June 8, 2022

Subject: **Response to Geotechnical Peer Review Comments Regarding  
2204-107-SUB1-PLANS**

Proposed Mercer Island Treehouse Residence  
5637 East Mercer Way  
Mercer Island, Washington

FOUNDATION PLAN

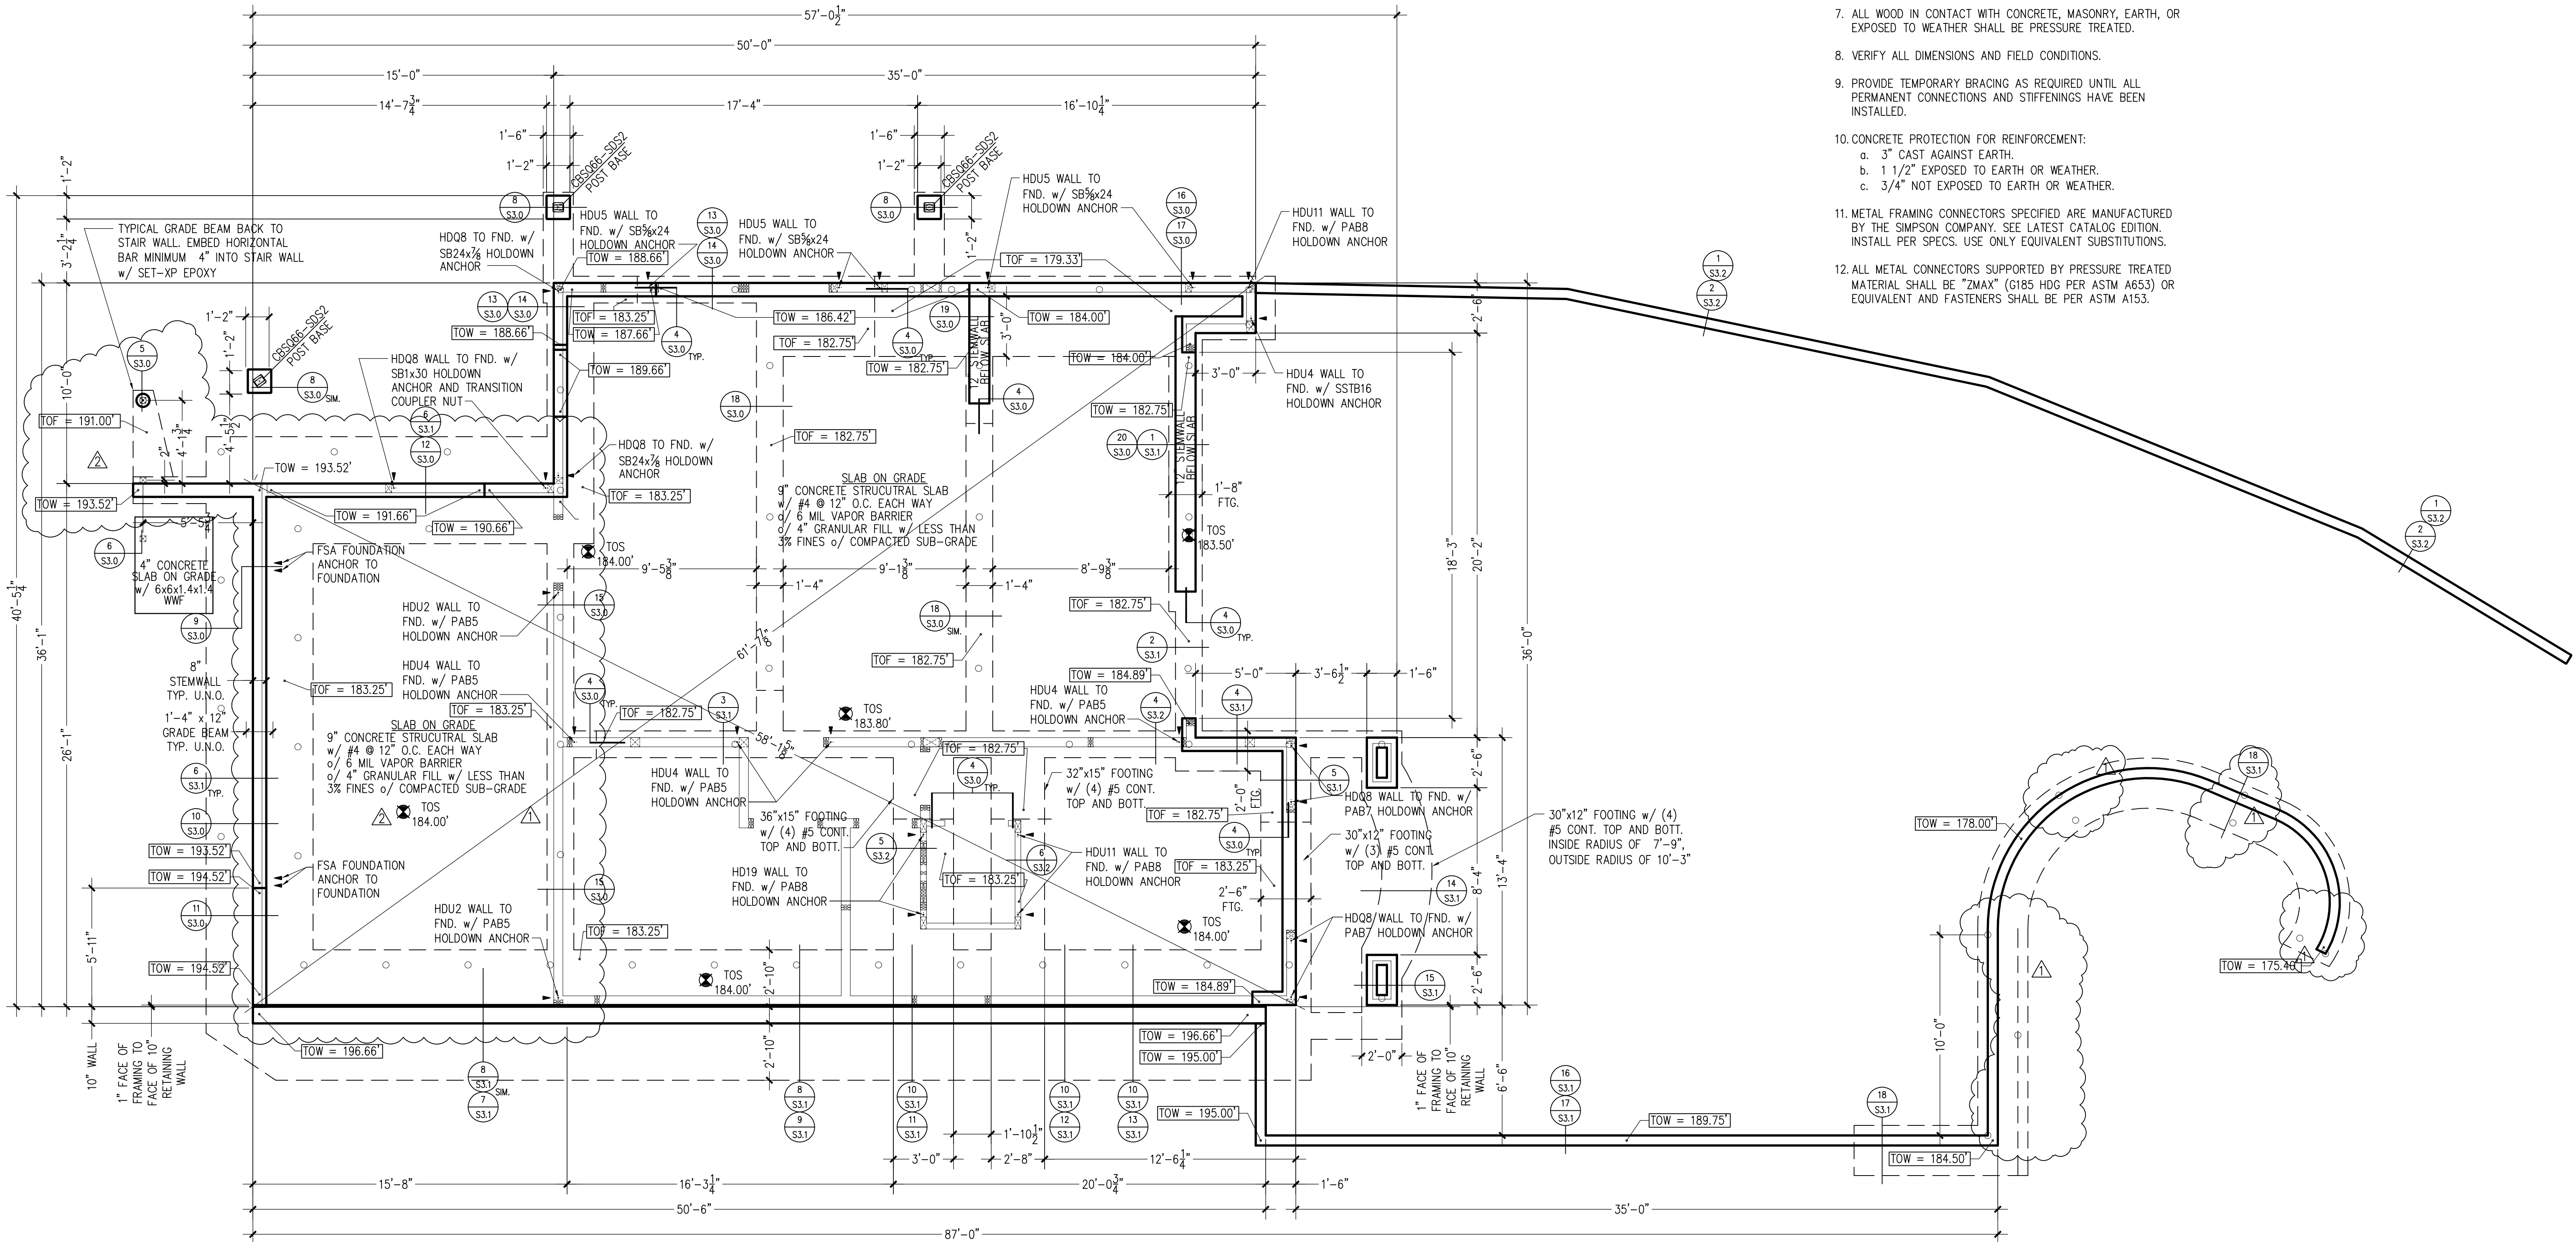
**Number: 1** *The geotechnical report recommended a structurally supported slab. Resolve discrepancy.*

**Number: 2** *The geotechnical report dated 3/12/2015 indicated that the site soils are liquefiable. The geotechnical engineer should assess to what depth these soils are liquefiable. What is the estimated post-liquefaction settlement? What is the potential for lateral spreading or flow failure? What magnitude of lateral deformation is estimated? Include discussion of how the post-liquefaction condition impacts the proposed structural design, for example, piling embedments, lateral earth pressures associated with a liquefied soil condition, lateral loading associated with flow failure or lateral spreading, etc. Provide mitigation recommendations for consideration by the project team. Provide this information with supporting calculations and stability analyses in a report addendum.*

**Number: 3** *When the post earthquake assessment (liquefaction, settlement and lateral deformation) is provided by the geotechnical engineer, the structural engineer shall review and assess whether the proposed structural design can accommodate these settlements, lateral deformations and lateral loads without building collapse. Revise structural design accordingly.*

**Number: 4** *The geotechnical report did not recommend shallow foundations but the use of pin piles or helical anchors for foundation support. Resolve discrepancy. Verify that retaining walls are designed for seismic loading.*

**Response:** The note on S2.0 clearly indicates that the concrete floor slab would be a structural slab that will span between the pile-supported foundations. The slab is 6 inches thick and reinforced with a mat of rebar. The term "Slab On Grade" used before "6" Concrete Structural Slab" simply refers to the fact that the structural slab will be poured on soil, rather than being elevated.

There is no need to modify the plan for this item.

**Response:** The potential for liquefaction and resulting ground settlement or soil bearing strength loss has been studied for many years, but it is still impossible to accurately determine where, and to what extent, liquefaction could/will occur. However, liquefaction of the loose sand soils that lie beneath the water table has a high probability during the Maximum Considered Earthquake (MCE), which has a probability of occurring once in 2,475 years.

**Response:** The upper soils are loose, wet sands and should not be depended on to support retaining walls more than a few feet in height. Based on the expected heights of the walls to be installed along the south side of the driveway, they should be supported on piles.

The structural plans will be modified accordingly.
